City of Albuquerque Stormwater Construction Site Inspection Report

Project Name:	Juan Tabo Hills				
Location:	Juan Tabo Hills West				
Site Contact Name & Agency	Sherri Repiechowski	ESC File No.	M21E018		
	sherri@paulallenhomes.net	NPDES Id. No.	NMR1001A4		
Inspection Date:	11/19/21	Start/End Time:	11am		
CoA Stormwater Inspector:	James Hughes				
Construction Phase:	landscaping				
Type of Inspection:	<input checked="" type="checkbox"/> Regular	<input type="checkbox"/> Storm Event	<input type="checkbox"/> Post Storm Event >0.25"	<input type="checkbox"/> 311/Complaint	<input type="checkbox"/> Follow Up

BMP MAP LEGEND

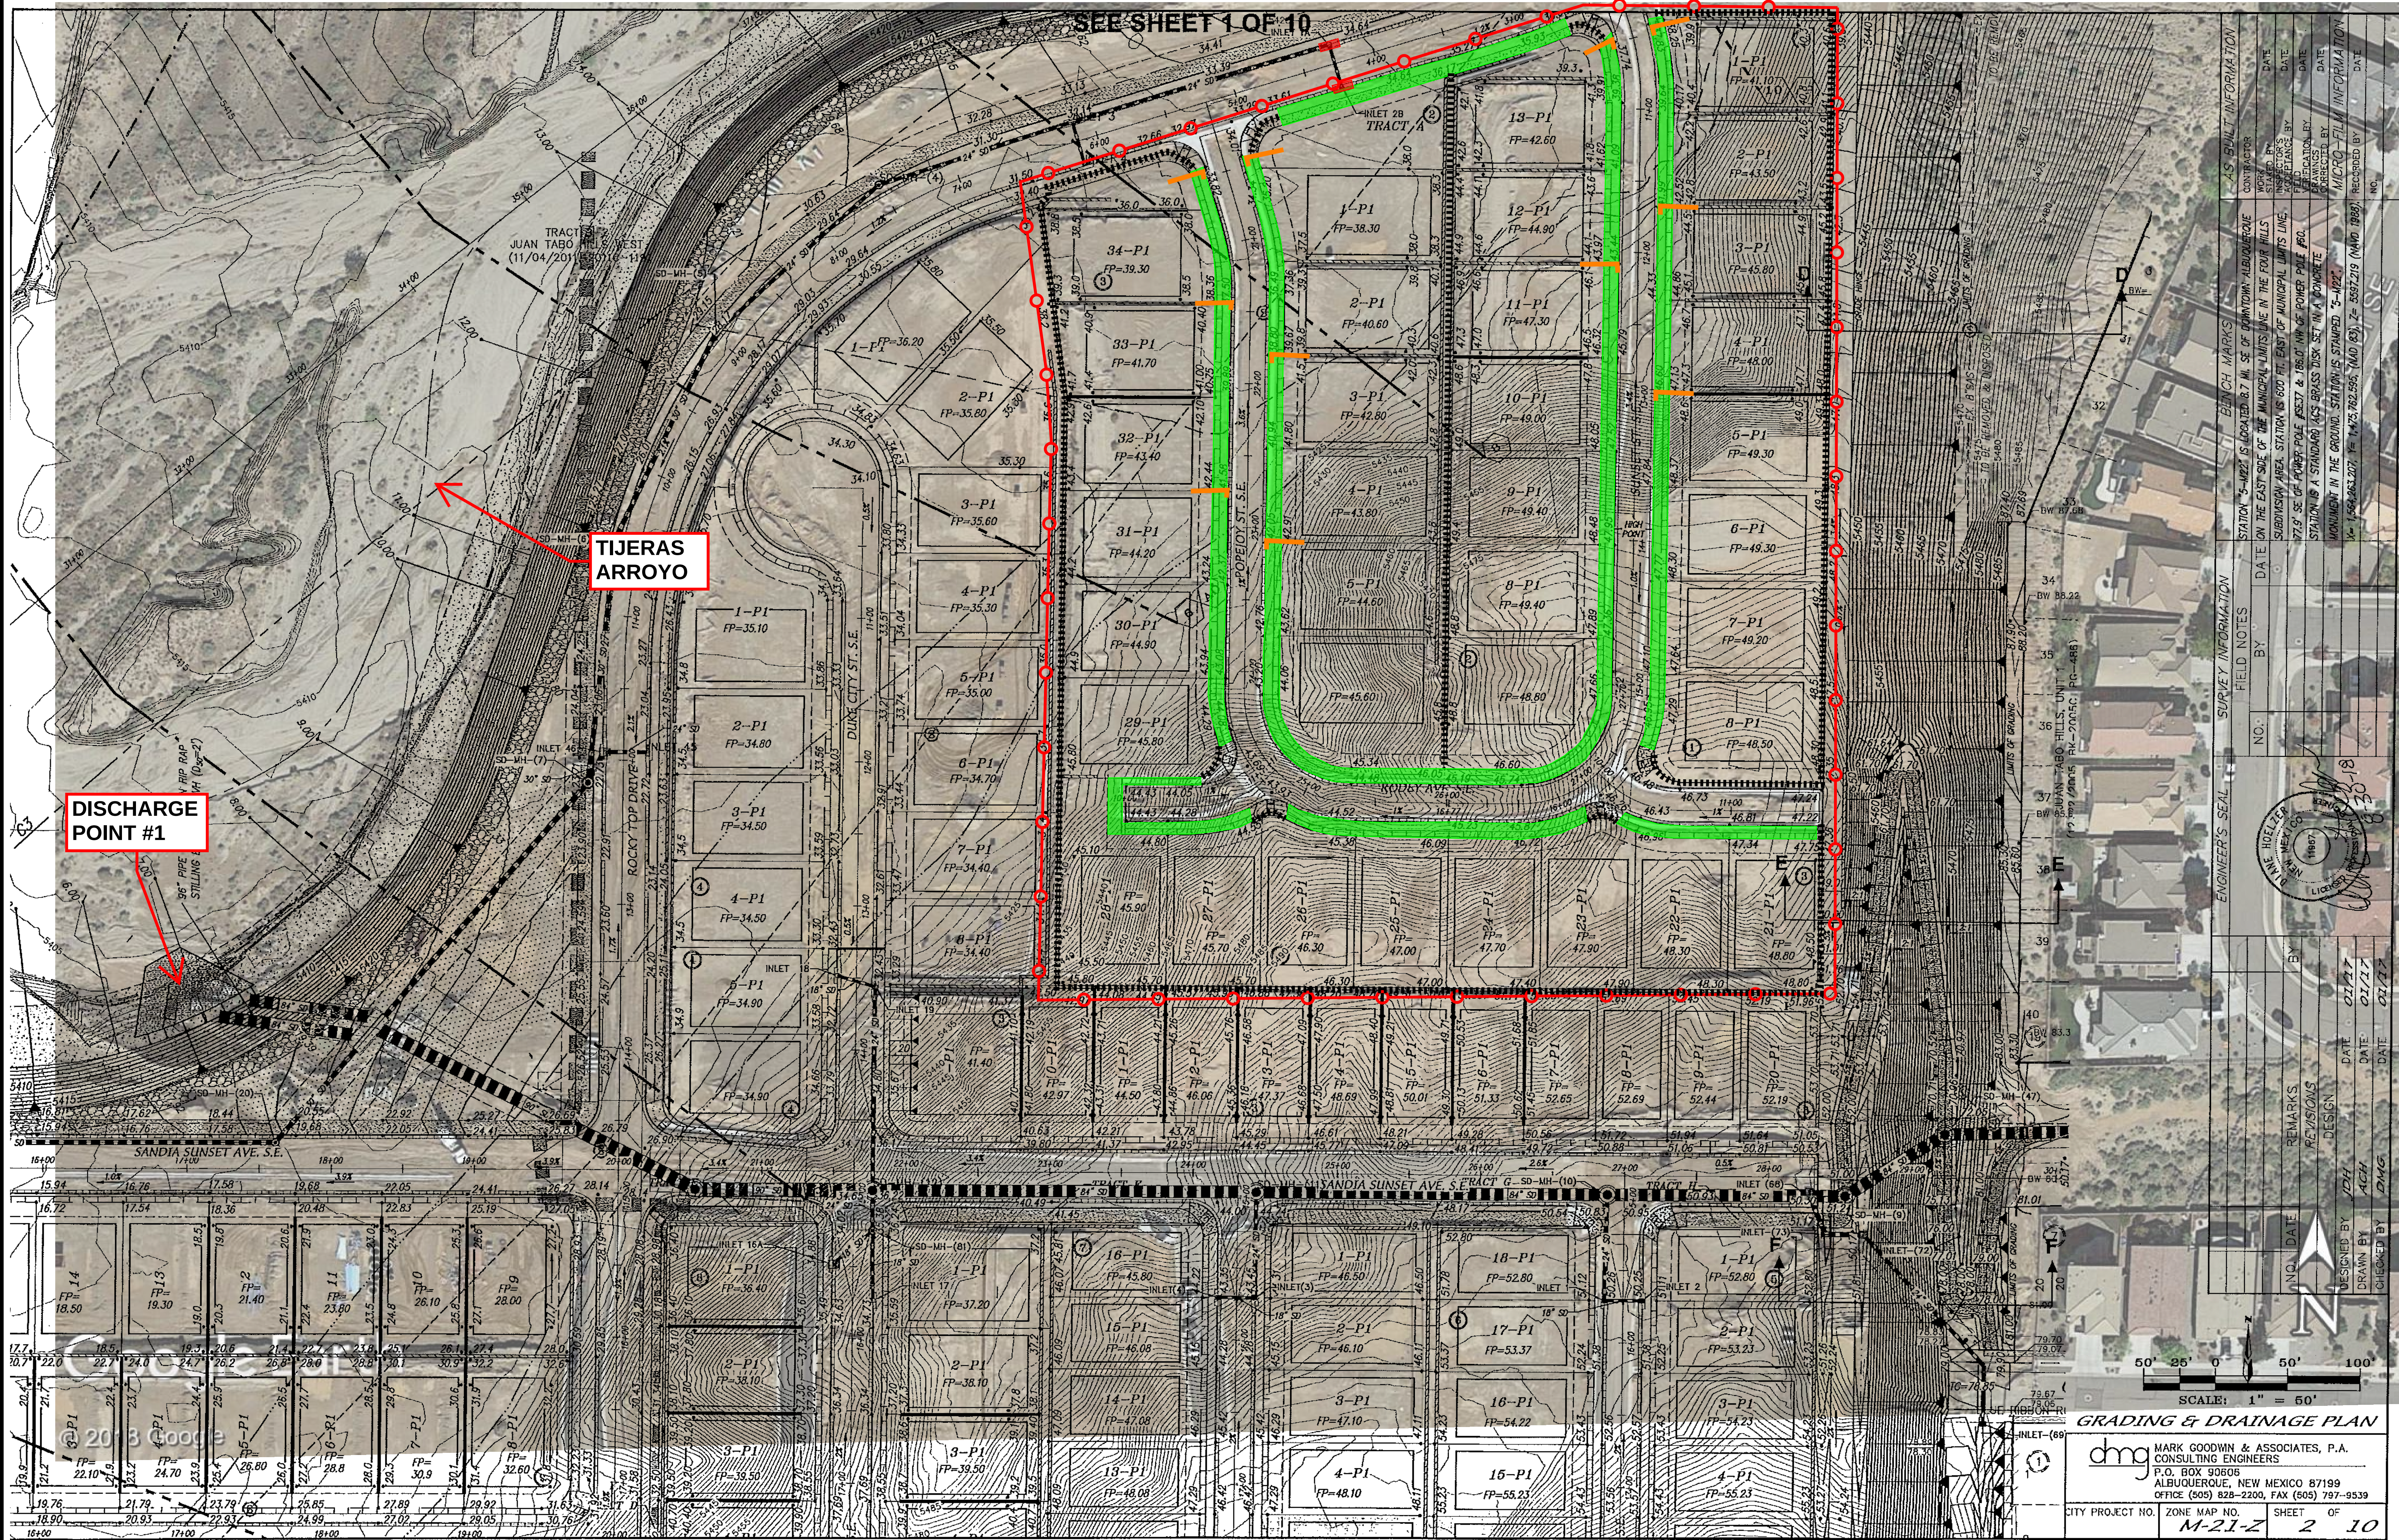
Item Number	Deficiency/ Corrective Action		
1	The up-to-date SWPPP was not available onsite. Keep it up-to-date and available onsite.		
2	Inlet Protection is missing from the inlet in the HOA tract at the east end of Sandia Sunset and sediment is at the inlet protection on Rocky Top north of Sandia Sunset. Maintain the Inlet protection and remove sediment from the street in the areas that are not next to the lots.		
3	Washout is on the ground in the HOA tract west of the Hubbard stub street. Remove the washout.		
4	Silt Fence needs reset at the south end of Canyon Wren next to HOA Tract. Reset the silt fence there and add additional silt fence in other locations to keep sediment from the HOA tracts out of the streets.		
5	Update the SWPPP map with all of the transfers and new BMPs		
6	The stabilization of the slopes in the HOA Tracts on the south and east side of the site doesn't satisfy the stabilization criteria in the CGP at Part 2.2.14. so BMPs must remain to keep sediment out of the streets, and inspection must continue until the site satisfies the CGP criteria.
